CITY OF PORTLAND, MAINE

July 26th, 2011

Project Name: Harborview Townhomes
New building comprising 7 residential units
(19 space parking lot shared with existing 12 unit residential building)
Project ID: 2011-214
Project Address: 127 York Street (aka 121-129 York Street)
CBL: 44 - A-004/005

TO: Jean Fraser, Planner
FROM: David Senus, P.E. & Ashley Auger, E.I.T.
DATE: June 23, 2011
RE: Harborview Townhouses, Level III Final Site Plan Application

NOTE:
SEE CIVIL DRAWINGS FOR
GRADING AND STORMWATER
MANAGEMENT.

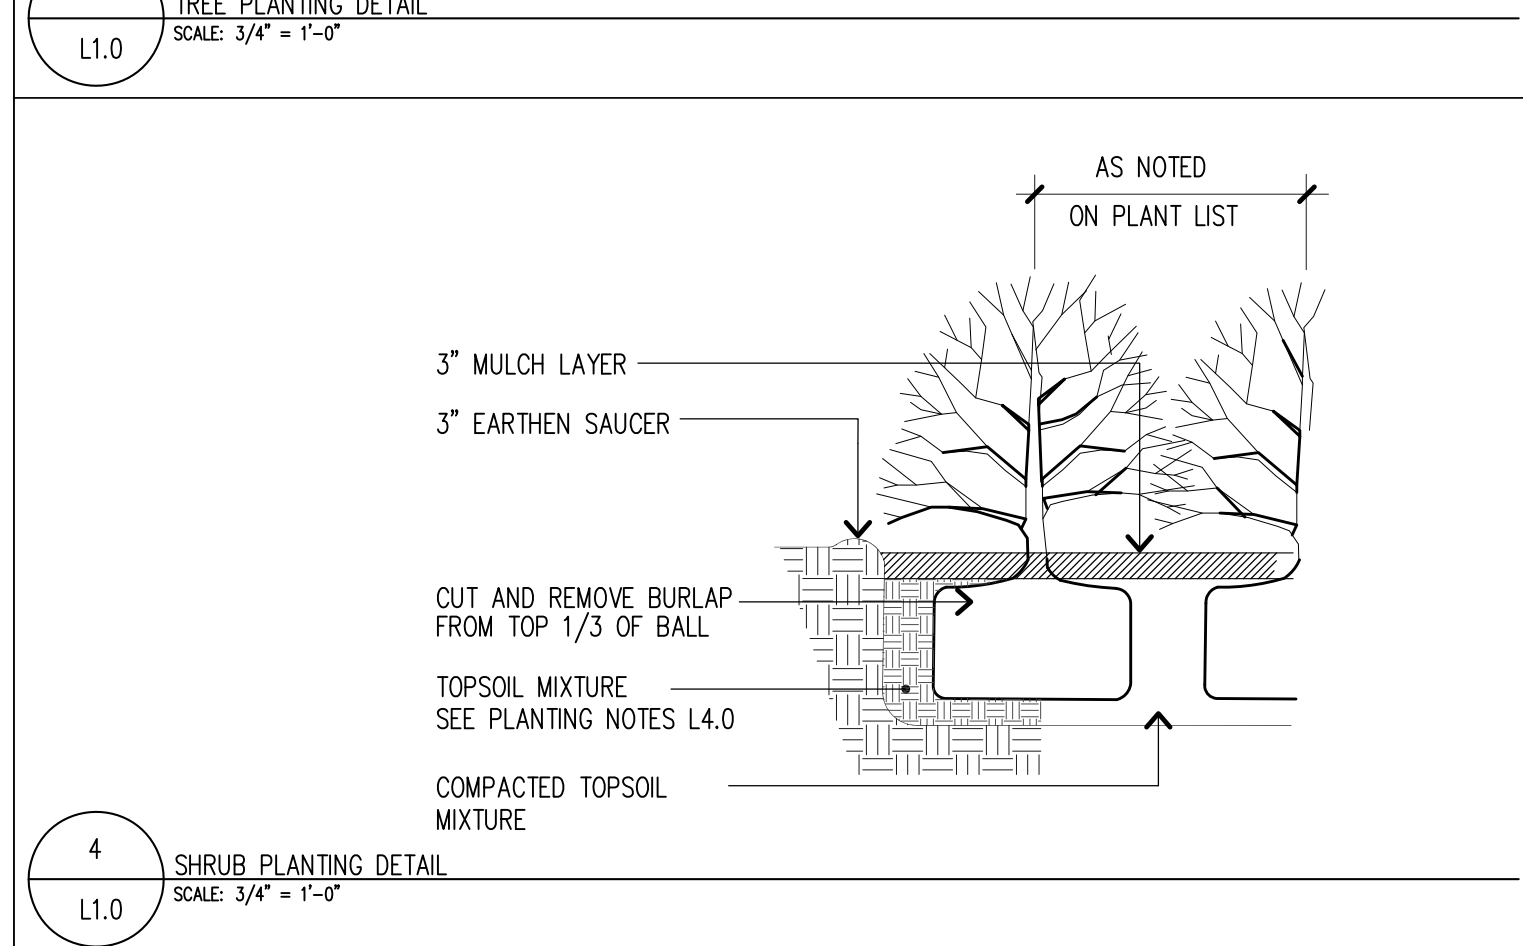
a) Landscape plan - the landscape plan, shown on sheets L-1.0 L-2.0 and L-3.0 should include a plant key or schedule that lists botanical and common plant name and location on the plan. While Sheet L-1.0 does show a Symbols Legend with plant names it would be good to have a more detailed plant key or schedule, Sheet L 1.0 shows (8) Amelanchier SP (1.75" CAL.) and (8) 'Armstrong' Red Maple (2.5" CAL.) with the later showing a larger graphic symbol finding the actual trees on the sheet could be clearer, I counted 17 circles or trees on design sheet and 16 trees on the Symbols Legend.

b) Tree Saves - the landscape plan Sheet L 3.0 shows details on tree protection, Sheet L 1.0 shows three trees, two along the sidewalk and one near the back corner of the existing building to be saved. The project should also take measures to protect trees on adjacent properties during site work, this would include root pruning exposed roots found during excavation and pruning any damaged limbs during construction. These items can be reviewed during the project 'Pre-Construction' meeting.

c) Street-trees & Parking Lot trees - The landscape plan includes two existing street trees along York Street and proposes to plant two additional trees ('Armstrong' Red Maples near the entrance driveway. The new street-trees are planted with tree grates, (Neenah R-8810 recommended) the location of tree on the right or High Street side of driveway may need to be adjusted to maintain sidewalk width for snow plowing and access. A second option would be to include this tree into the planting space with the other two trees. Parking Lot trees - the parking lot area contains 19 parking space creating a need for 10 trees to meet the Parking Lot Landscape Standard. The plan proposes six trees near the York Street entrance, three near the proposed building front and one near the existing building - which is "close". Ideally, one additional tree perhaps planted on the adjacent private property mid way up the right side of the parking lot would be a creative solution. It would help the parking lot standard and additional screening for the neighboring property.

d) Landscape treatment - In addition to the 'tree saves' and 'street & parking lot' trees the project mentions "planted landscape buffer" near the York Street entrance, 'individual garden terraces', 'raised planters along entry corridor', 'front patio garden' and two 'lawn' areas near the existing building are shown on Sheet L 2.0. Landscape treatment details, shrub and herbaceous landscape plant information and placement is needed on the plan. The landscape legend as shown does not mention any shrub planting.

- 1) Landscape Key / Plant List needed for trees, shrubs & herbaceous planting.
- 2) Tree Save - include tree protection measures to include 'off-site' trees.
- 3) Landscape Treatment, trees / shrub proposed for the areas shown as 'individual garden terraces', 'raised planters along entry corridor', 'front patio garden' should be included or shown in detail on the landscape plan.
- 4) to meet the standards of trees per unit and parking lot landscape three additional trees are needed.
